8th March 2022

Application No: AB/10/22/HH
Site Address: 75 Maltravers Street Arundel BN18 9BQ
Description of works: Single storey side extensions.
(This application may affect the setting of a Listed Building. This application affects the character and appearance of the Arundel Conservation Area).

Thank you for your internet representation made on 7th March 2022 which has been recorded as an objection with the comments as follows:

Elevation 1 - south west
Datum 49.00m

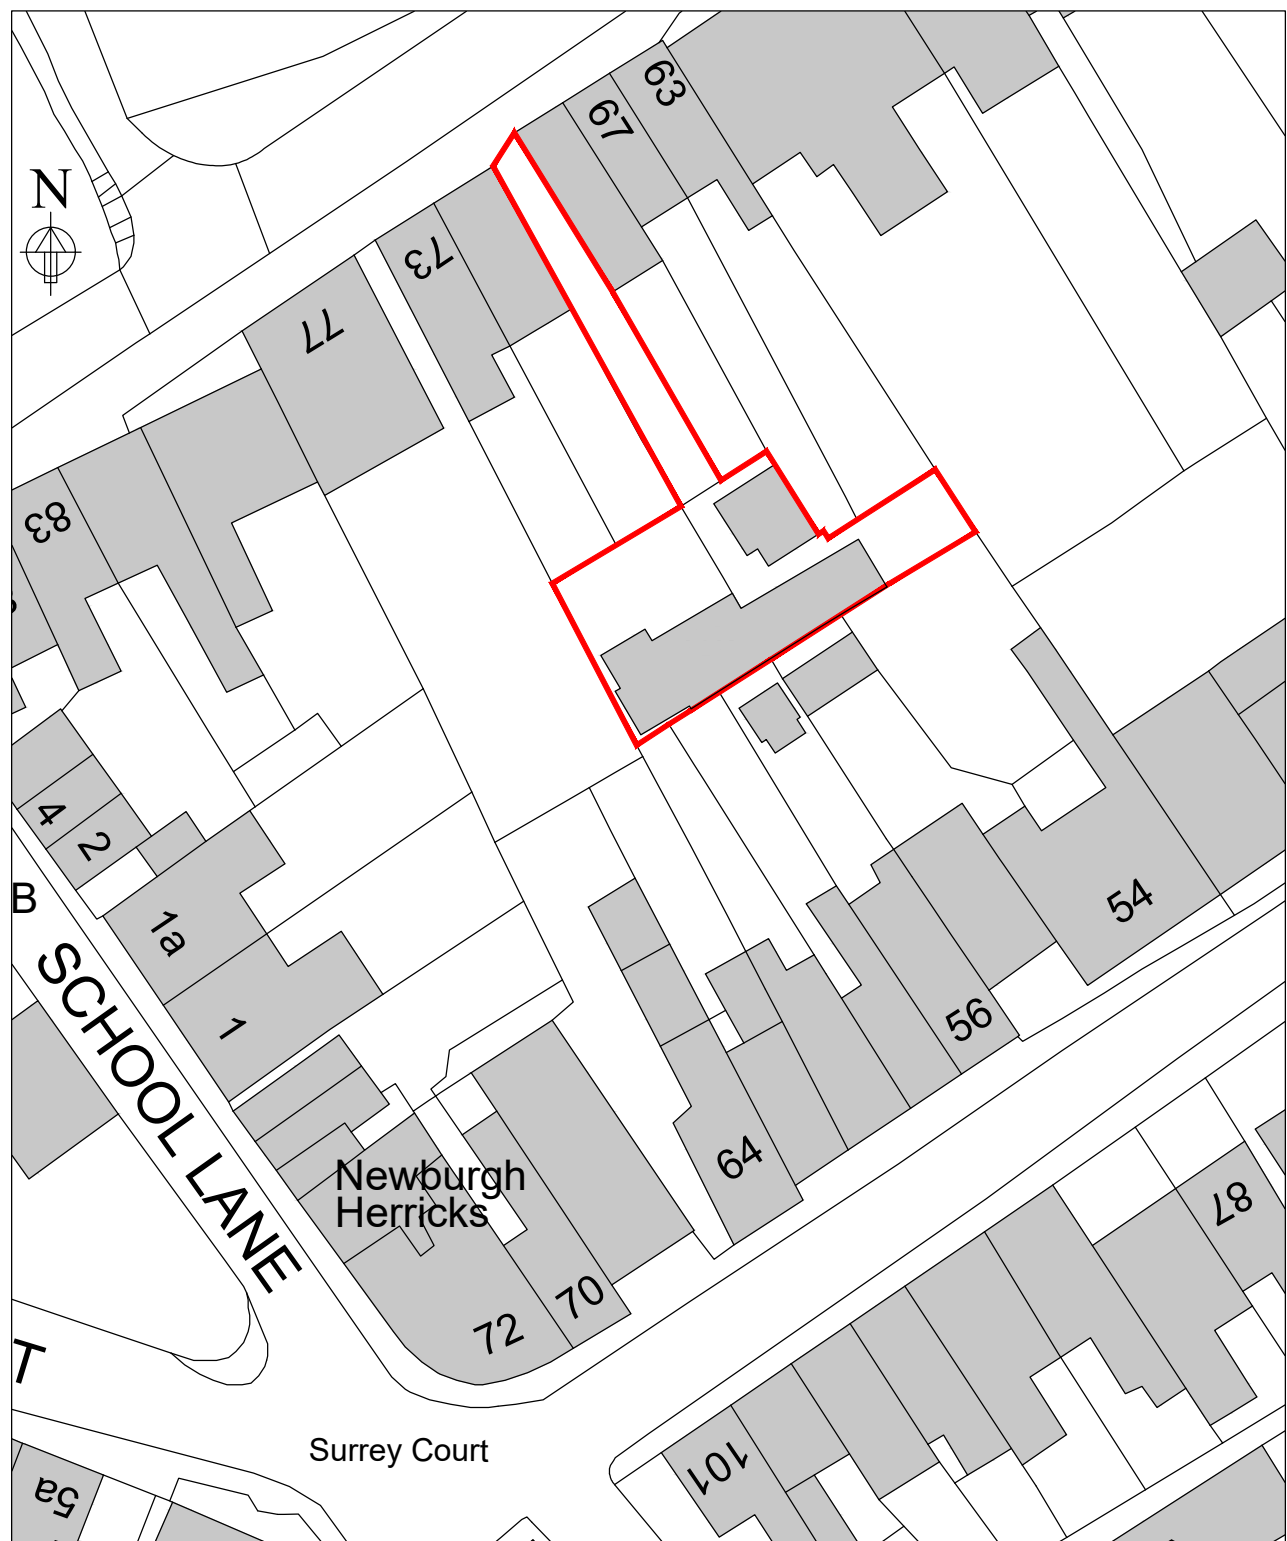
The Committee objected to the Application based on the use of the material choices of PVC double glazed windows, not achieving a visual quality in accordance with policies HER DM3 and D DM1 of the Arun Local Plan.
